OXFORDSHIRE COUNTY COUNCIL'S RESPONSE TO CONSULTATION ON THE FOLLOWING DEVELOPMENT PROPOSAL

Application no: 21/03177/F

Proposal: Full planning application for employment development (Use Classes E(g)(iii), B2 and/or B8) and associated parking and servicing, landscaping and associated works

Location: Axis J9 Phase 3 Howes Lane Bicester

PHASE 3 External Works & Levels

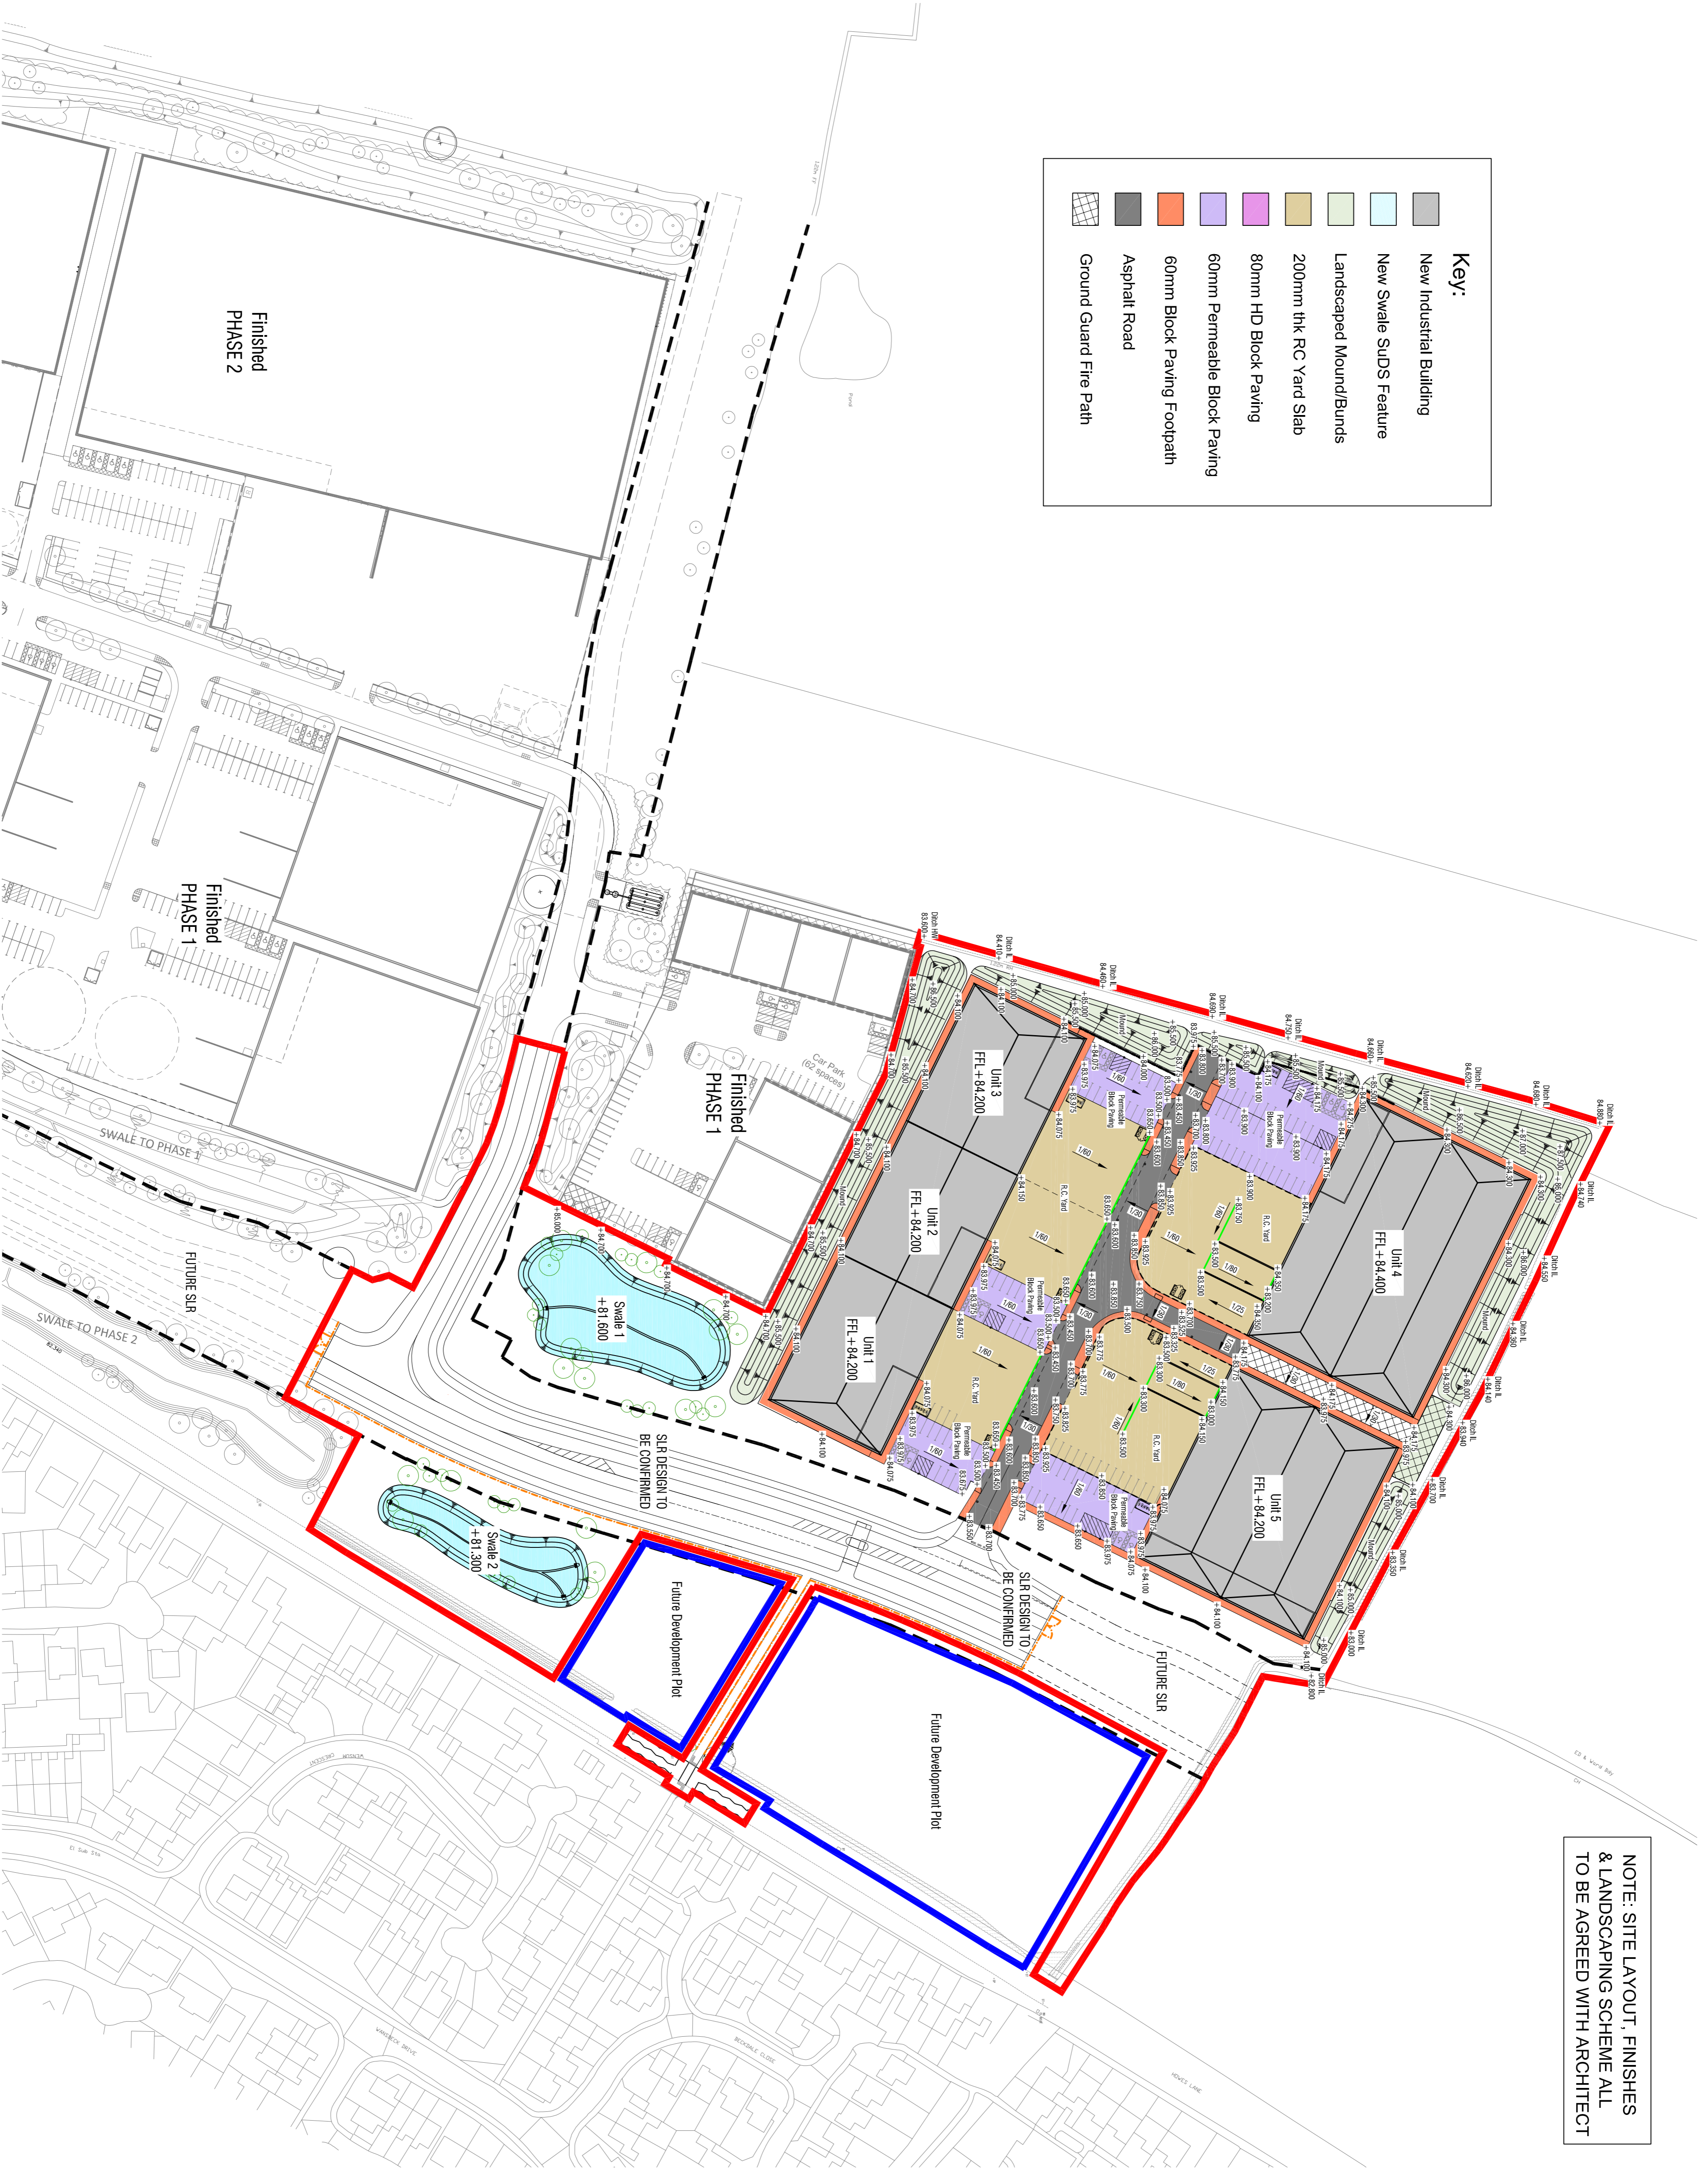
No updated drawing/report provided to address previous LLFA comments dated 24/02/2022.
